CITY OF PORTLAND, MAINE
HISTORIC PRESERVATION BOARD

January 16, 2013

Re: Request to install wall sign – 443 Congress Street

Portland, Maine
 Building South Elevation
 Proposed

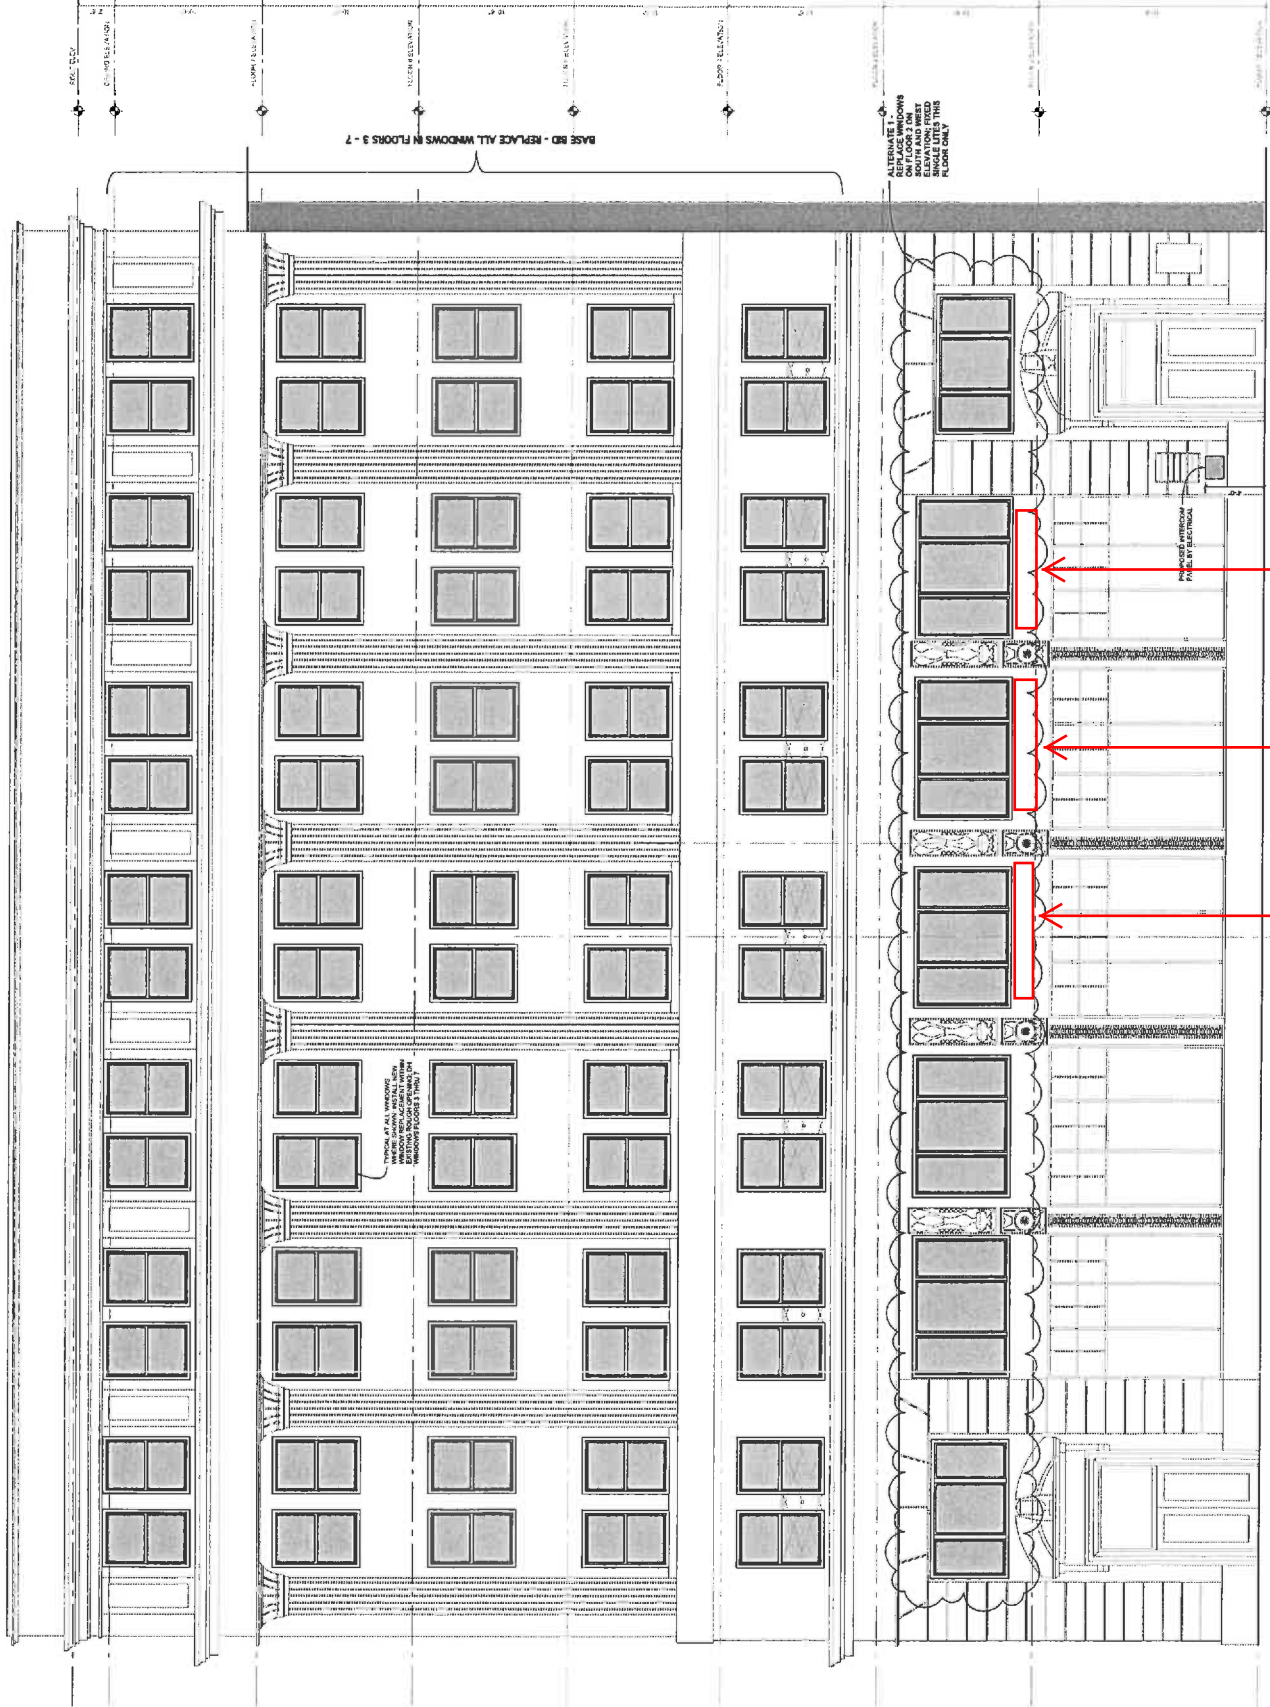
1. The approved version of the sign was received by Historic Preservation staff on 1/15/13, from Peter Martin. This version has the BlueTarp logo and the typeface smaller than in the original submission, completely within the dark blue sign background, with a minimum of 1.5 inches of background showing on all sides of the logo.
2. It is the understanding of Historic Preservation staff that no lighting is to be included in this installation.

All improvements shall be carried out as shown on the photos, drawings, and specifications submitted to staff on 12/19/2012, except as specified in the conditions above. Changes to the approved plans and specifications and any additional work that may be undertaken must be reviewed and approved by this office prior to construction, alteration, or demolition. If, during the course of completing the approved work, conditions are encountered which prevent completing the approved work, or which require additional or alternative work, you must apply for and receive a Certificate of Appropriateness or Non-Applicability PRIOR to undertaking additional or alternative work. This Certificate is granted upon condition that the work authorized herein is commenced within twelve (12) months after the date of issuance. If the work authorized by this Certificate is not commenced within twelve (12) months after the date of issuance or if such work is suspended in significant part for a period of one year after the time the work is commenced, such Certificate shall expire and be of no further effect; provided that, for cause, one or more extensions of time for periods not exceeding ninety (90) days each may be allowed in writing by the Department. Please note a Certificate of Appropriateness does not constitute a building permit.
